Rustington Parish Council

Our ref: CW/CH/PLAN/08
Date: 19 March 2008

CZF **R/46/08 – Demolition of existing bungalow and erection of 3 No. dwellings – 22 Mill Lane, Rustington**

ARUN DISTRICT COUNCIL		
No.	R	46 08
SUBSTITUTION		
RECEIVED	20.2.08.

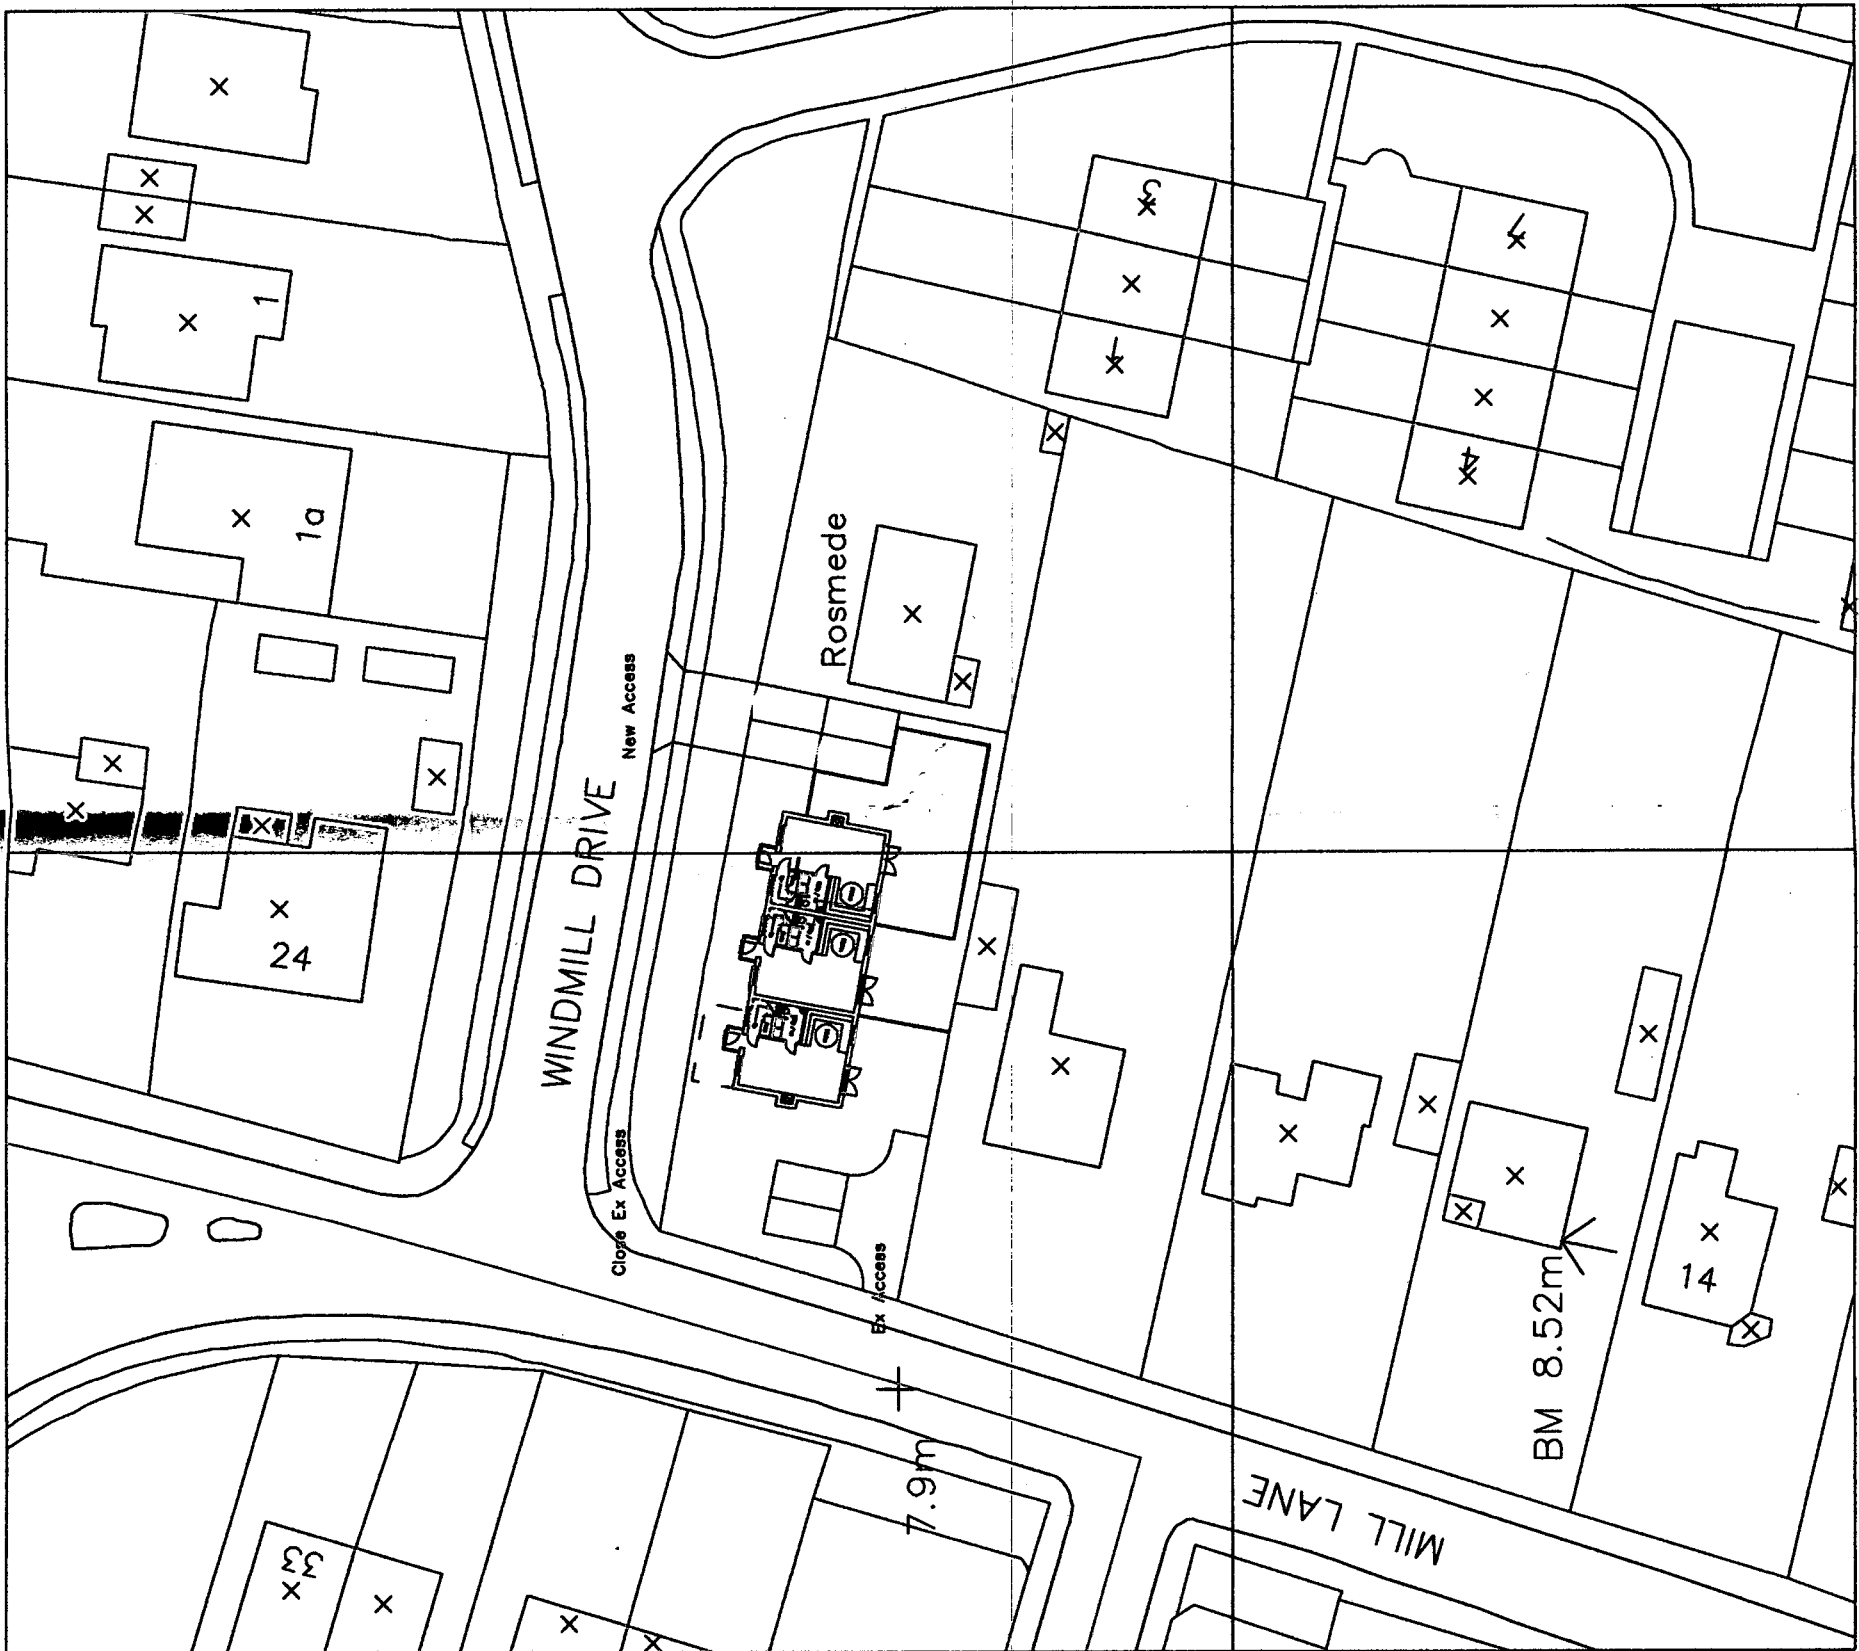
- (i) The proposal to erect three units of accommodation would constitute an undesirable intensification of residential development, at a density which would be out of keeping with the existing development in the area, and would most certainly represent an over-development of the site

- (ii) Having regard to the limited area of the site and its relationship to existing residential properties, the proposal would present an over-bearing and unsympathetic appearance to the occupiers of the neighbouring properties to the east and south, which would not only result in a serious loss of privacy, but would also be severely detrimental to their quiet enjoyment and visual amenities

- (iii) The formation of a new access onto the highway would lead to an increase in the movement of vehicles in a busy through road, which would be detrimental to not only road users, but would adversely affect the privacy and quiet enjoyment of the neighbouring property to the east

- (iv) The use of a new access to the site would lead to an unacceptable level of disturbance to the property immediately to the east, namely Rosmede, Windmill Drive
